**Our Case Number:** ABP-317121-23

**Re:** BusConnects Swords to City Centre Bus Corridor Scheme  
Swords to Dublin City Centre

Re: Case 317121 - BusConnects Swords to City Centre Bus Corridor Scheme

SWORDS TO CITY CENTRE SCHEME FRANK FLOOD BRIDGE COVER SHEET

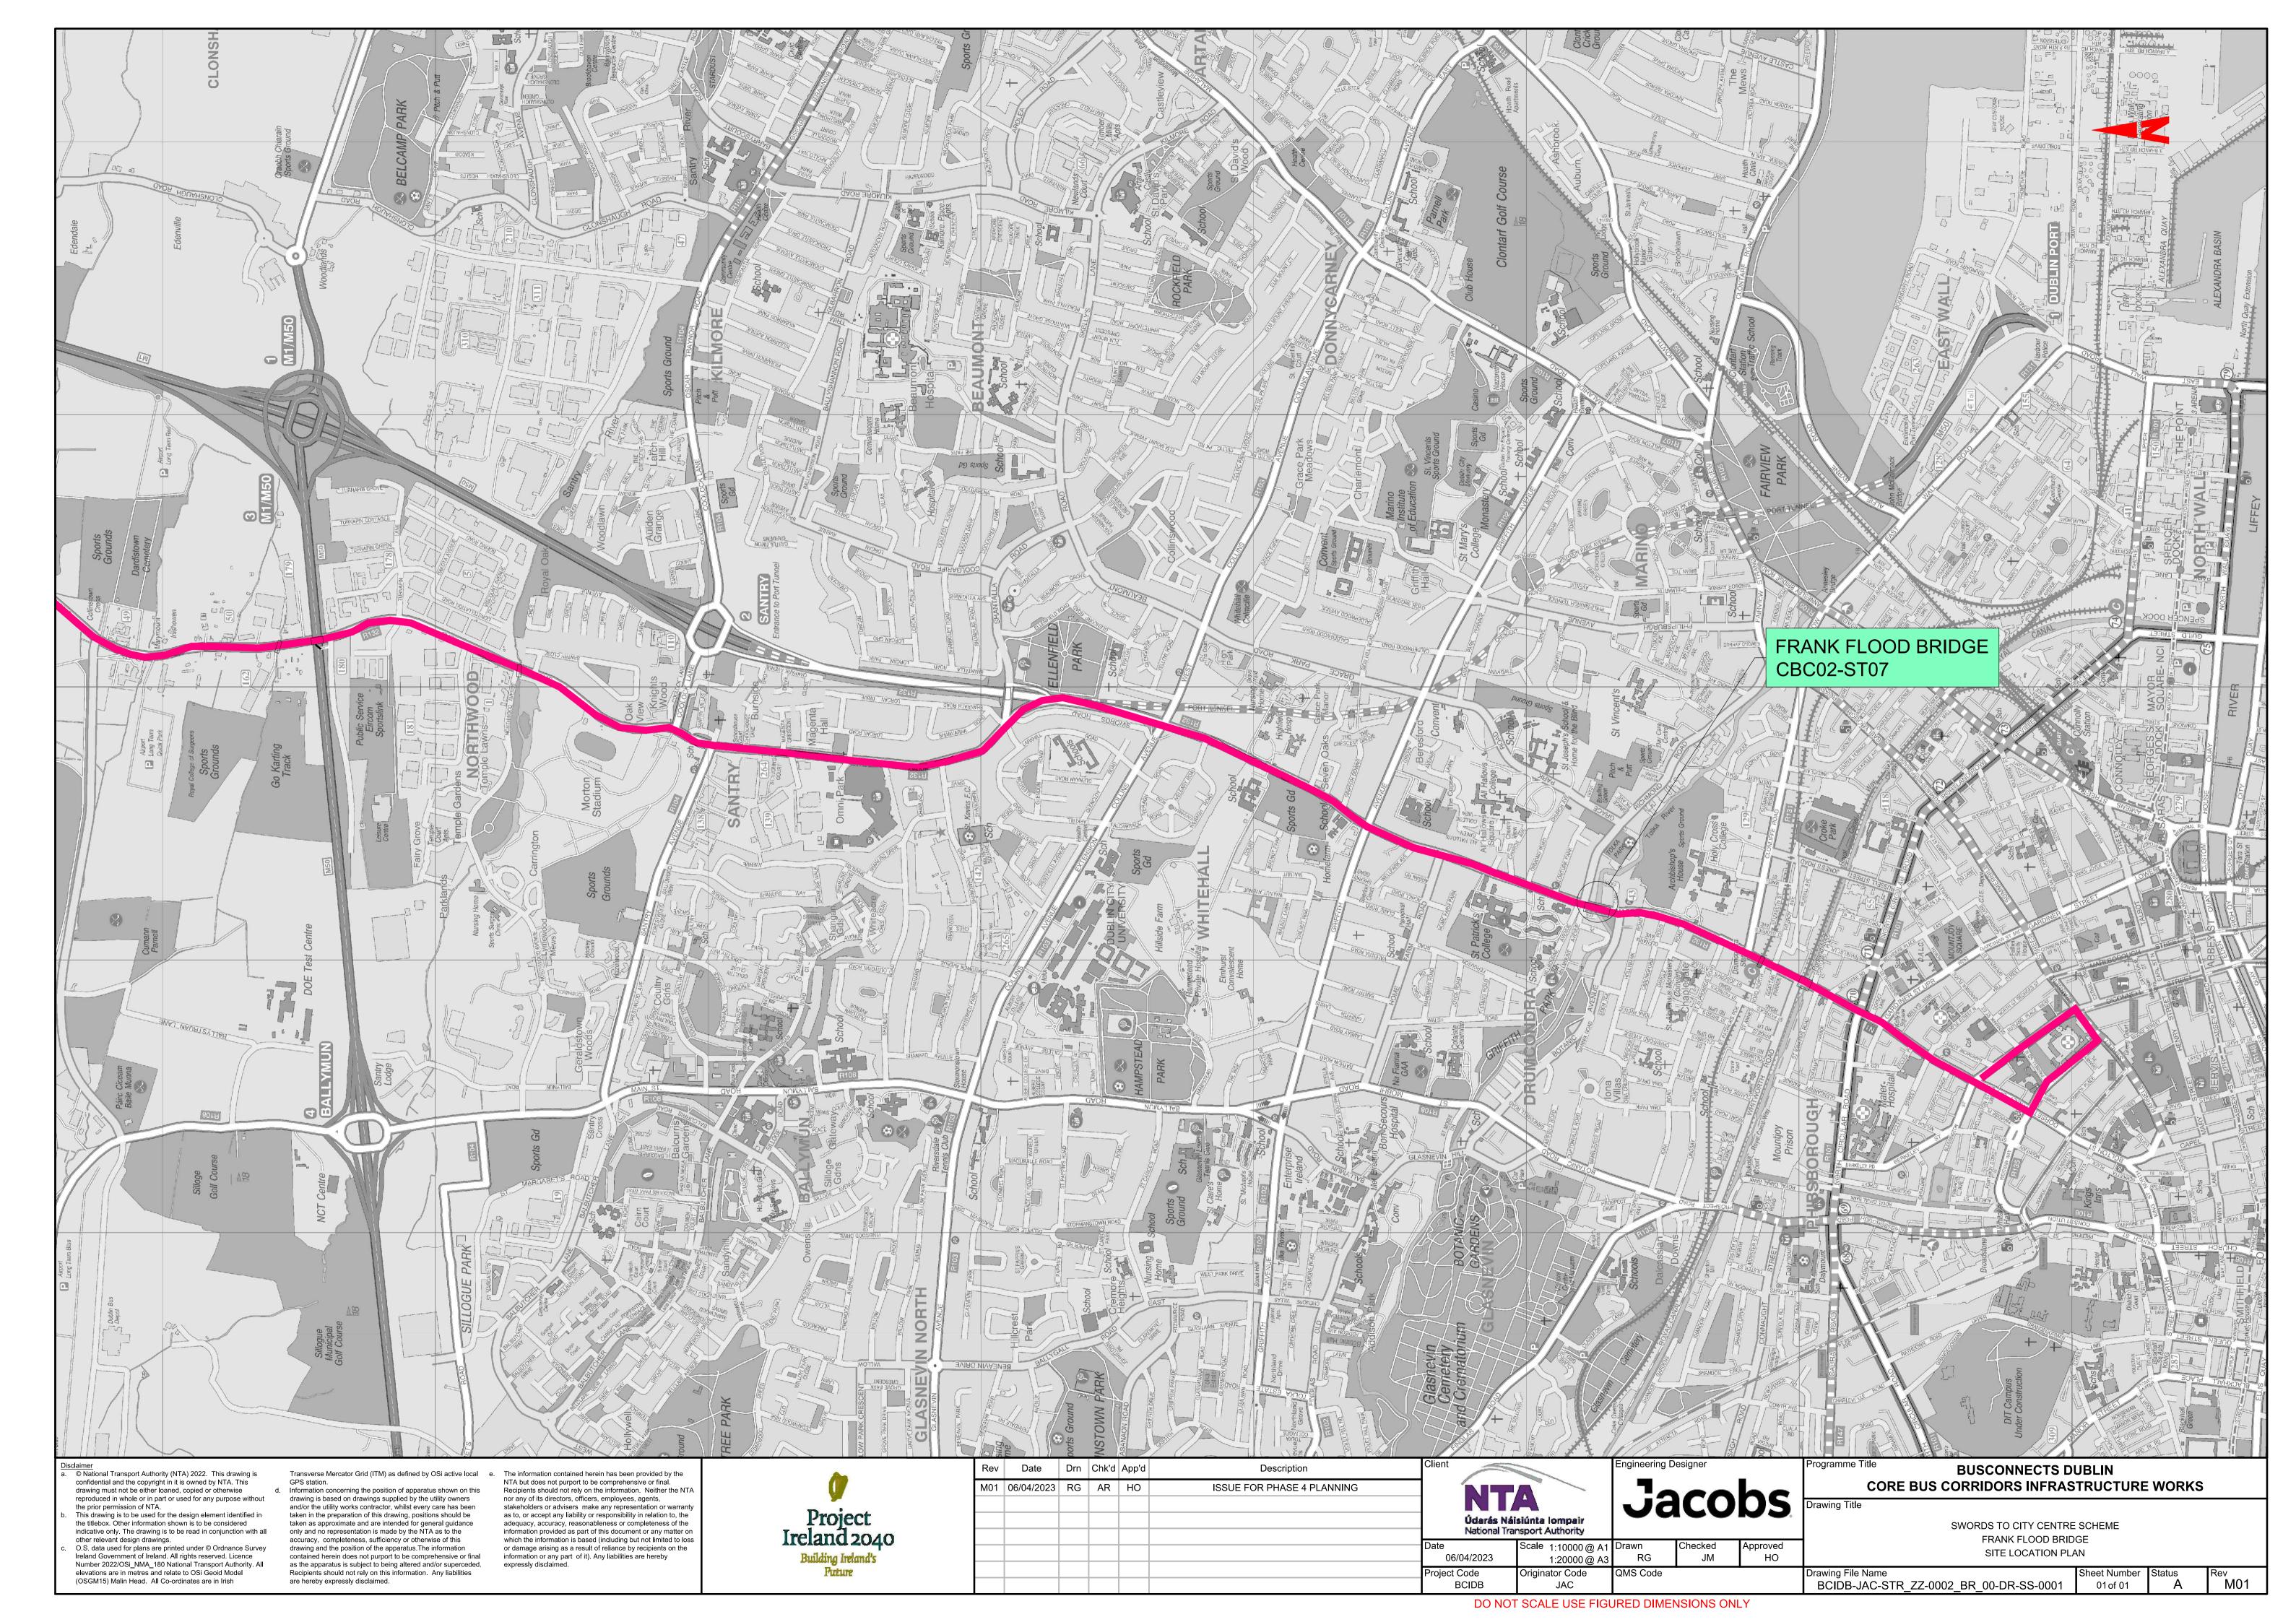
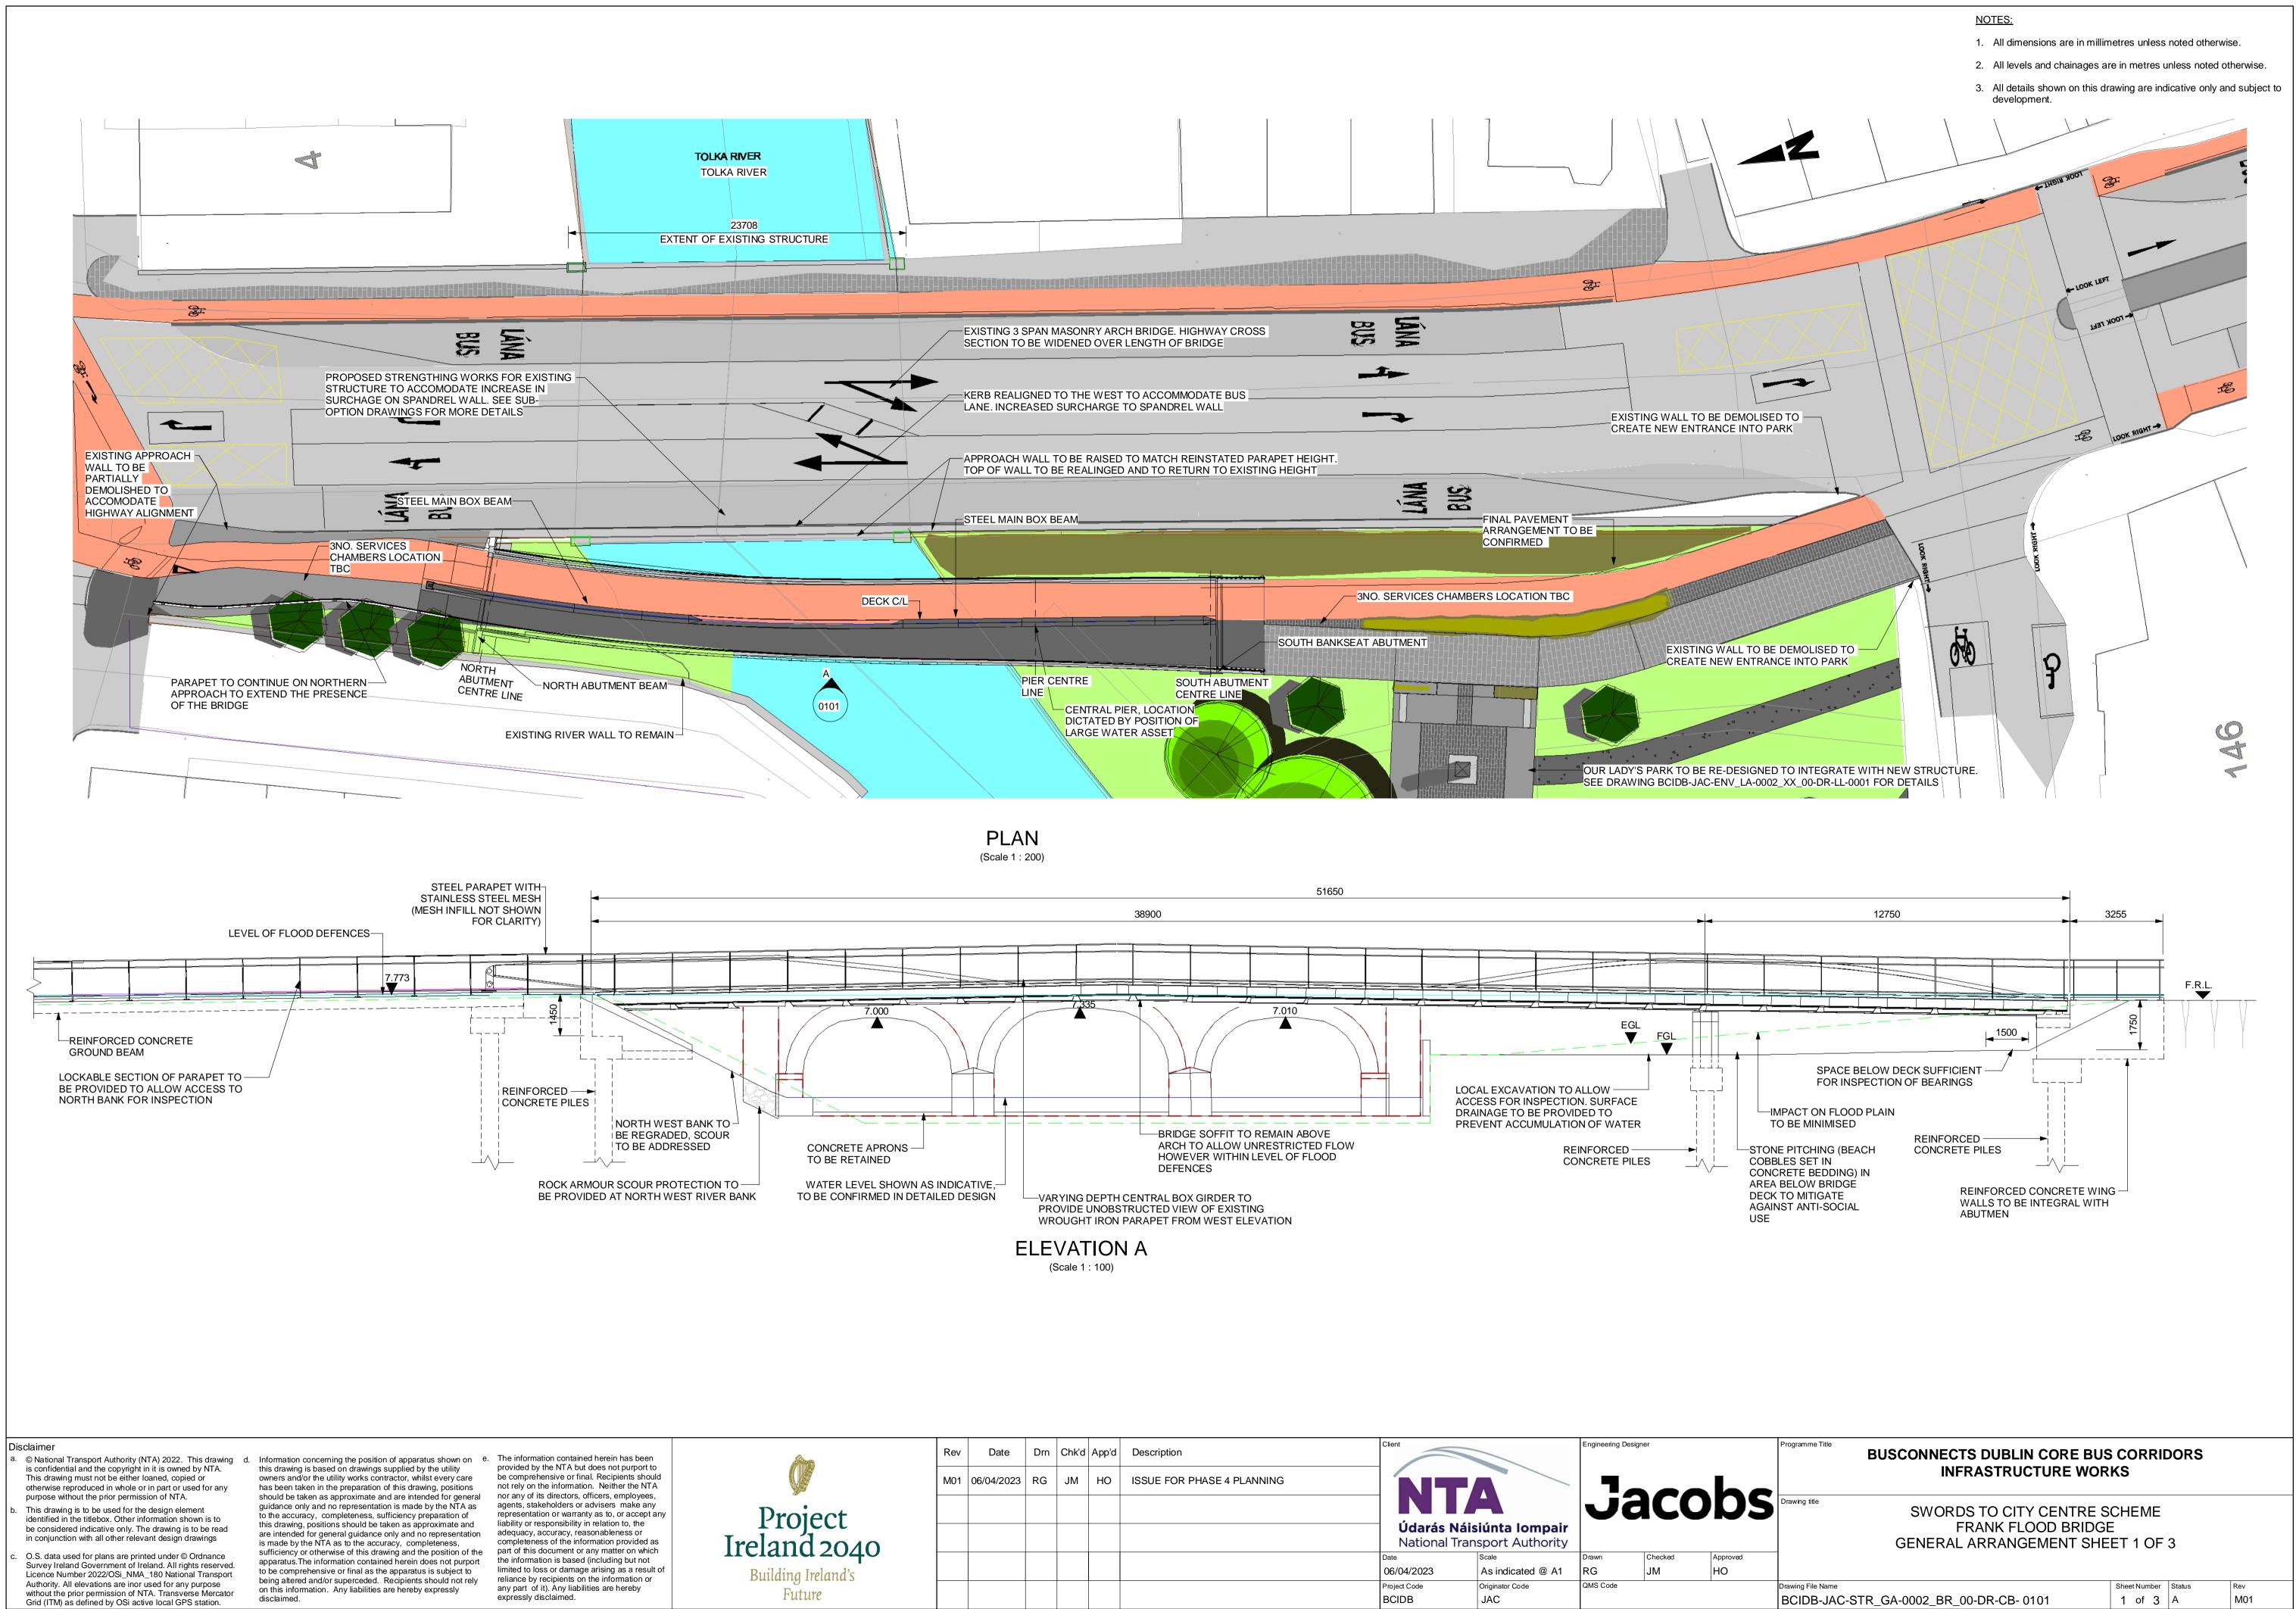
Some constituents have concerns that the modern design of the new pedestrian/cycle bridge at Frank Flood Bridge is not in keeping with the prevalent architectural style of the area (e.g. Edwardian/Victorian) and the existing bridge. While a pastiche treatment is unlikely to be successful something a little less jarring might be more appropriate.
